Engineers Comments Regarding Surface Water Drainage

Application Reference:	P/40/25/PL	Reviewer Reference:	ADC/EXT4
Planning Officer:	Amber Willard	Date of Review:	12/12/2025
Site Name:	Sefter Farm Pagham Road Pagham PO21 3PX		
Application Description:	Erection of warehouse extension and remodelling of existing reservoir. This application is in CIL zone 5 (zero rated) and may affect the setting of a listed building.		
Assessment Number:	2 of 2

TITLE Existing Ditch Details

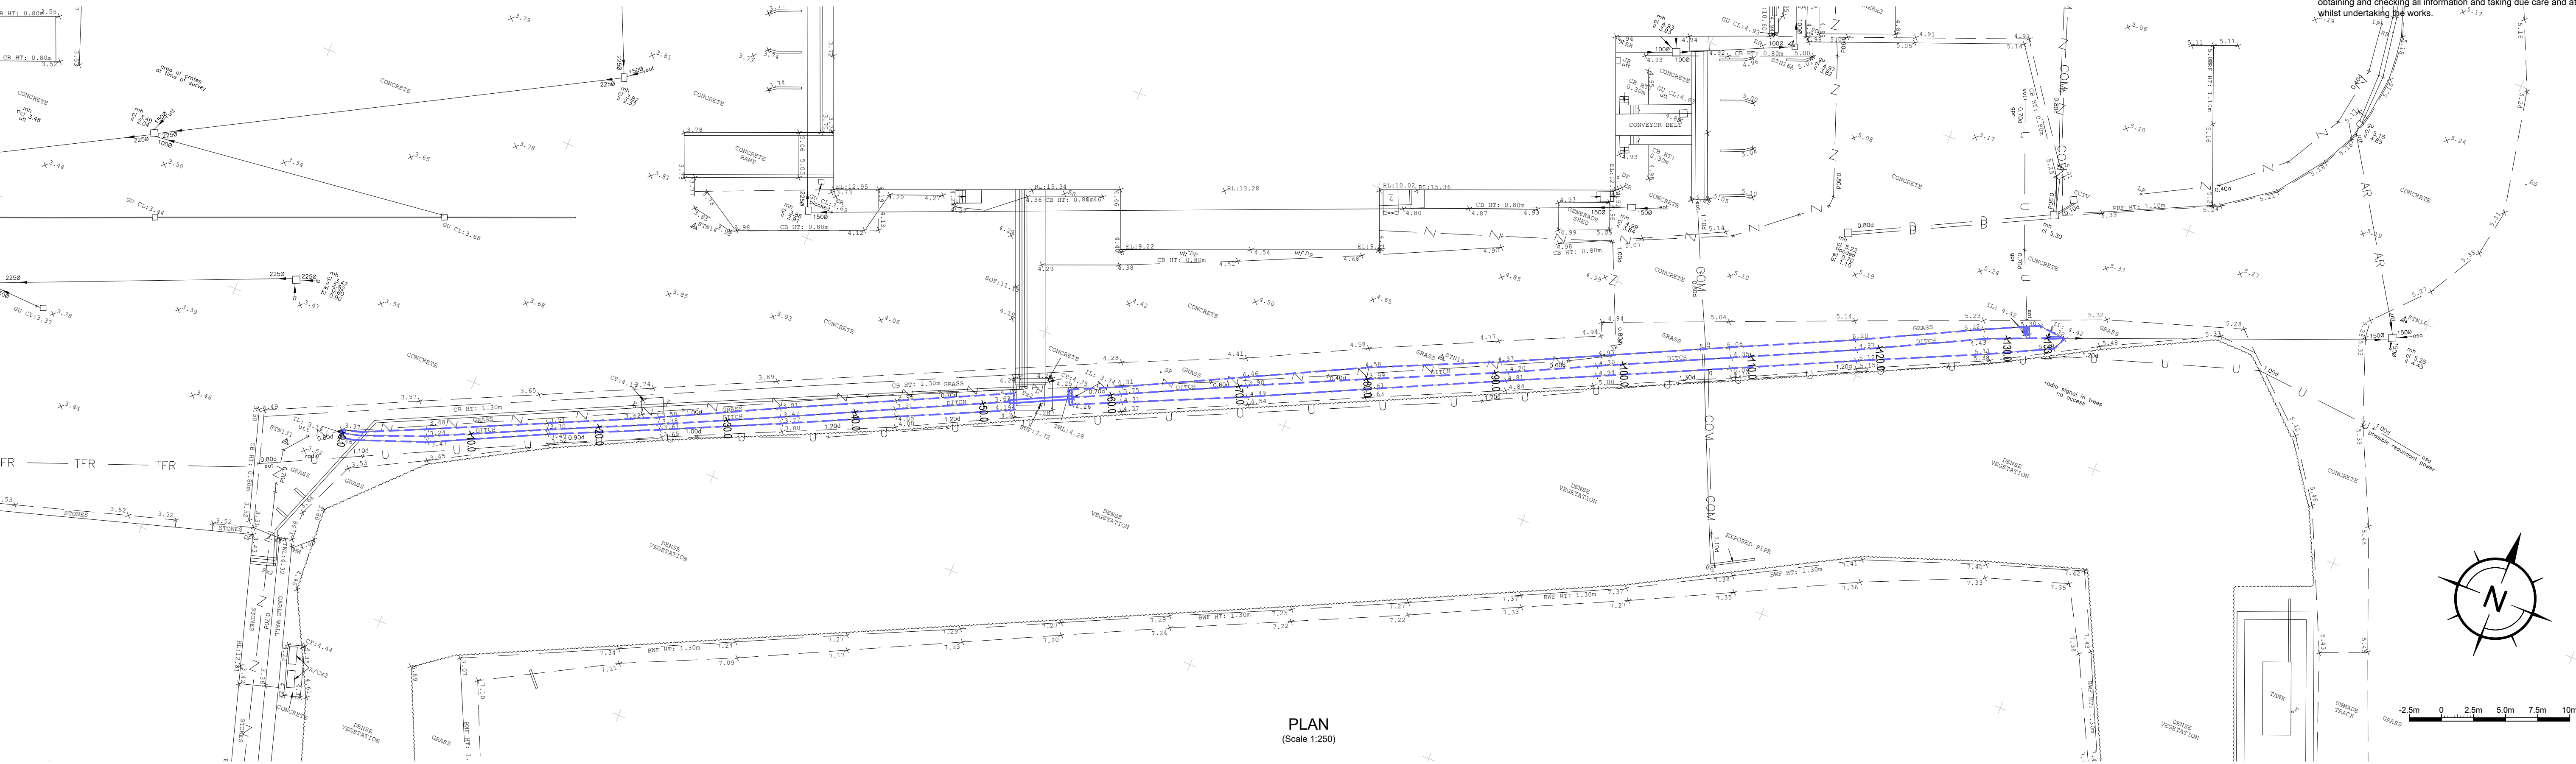
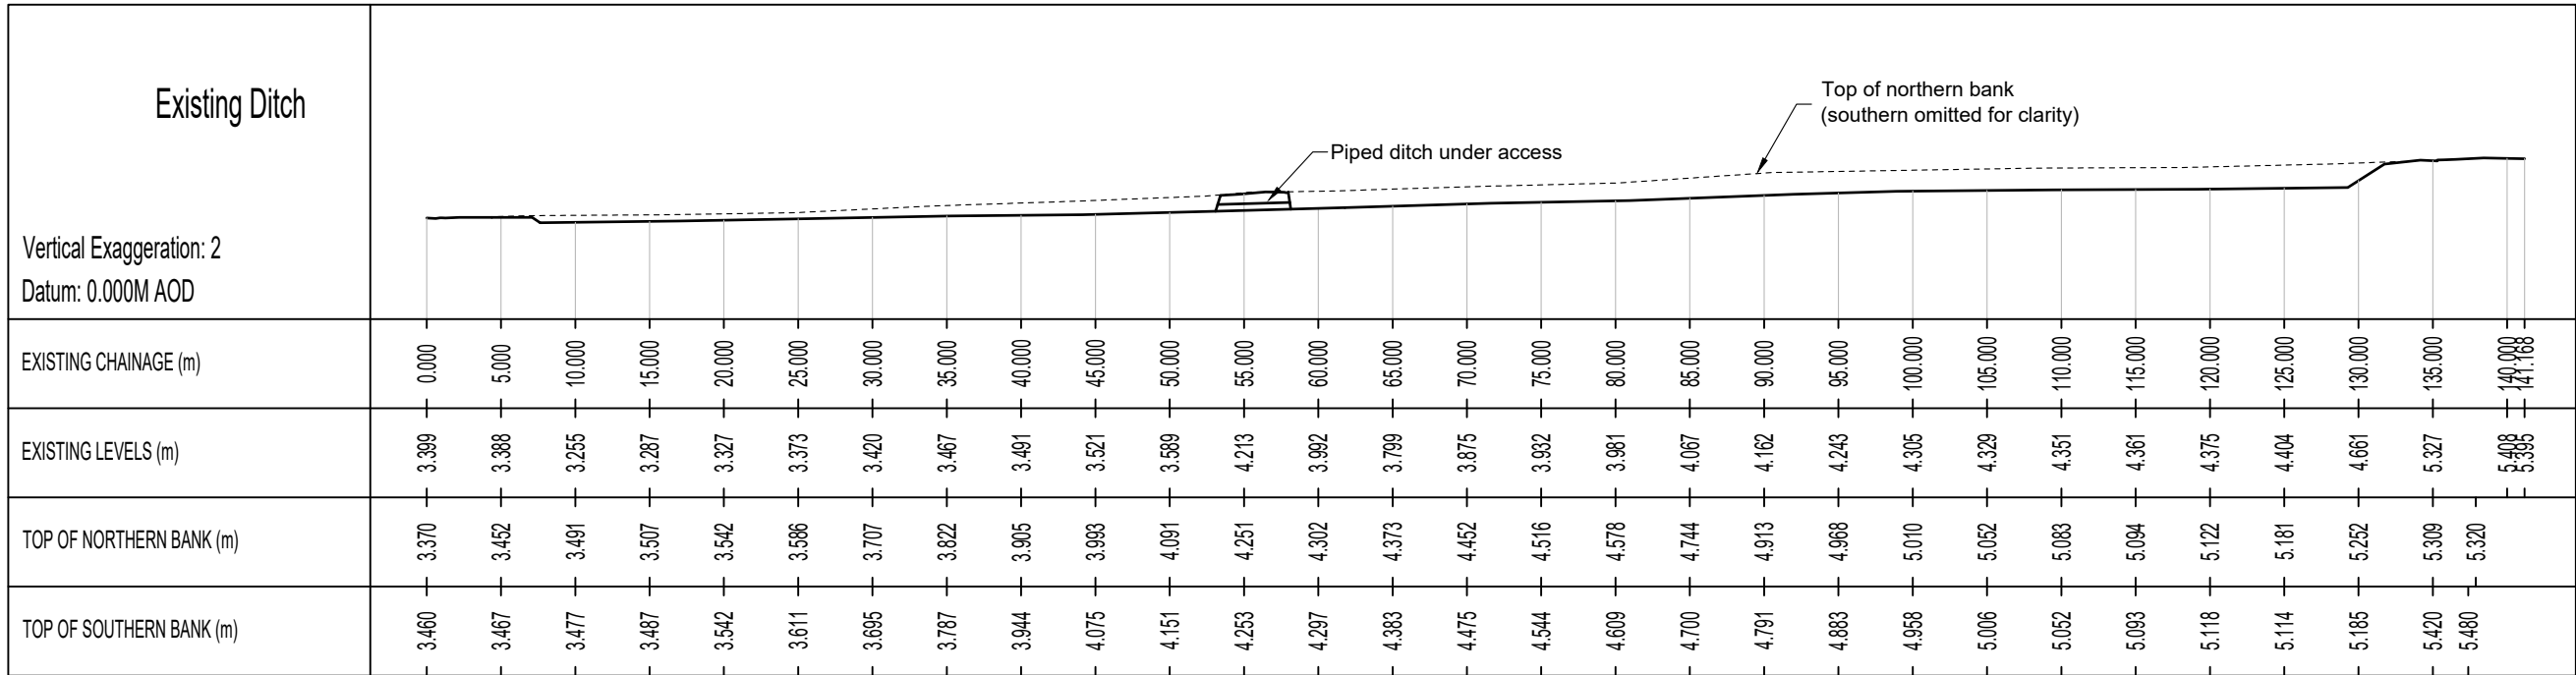
- 0.5. It is noted that there are proposals to divert the existing watercourse. Evidence of positive dialogue over these proposals with the LLFA is required to ensure that these proposals will be acceptable. The applicant will need to obtain an Ordinary Watercourse Consent in order to carry out any works or diversions to this existing watercourse

6.1. No assessment has been provided, though the diverted ditch does appear to provide an enhance and larger feature. Further supporting details should be provided
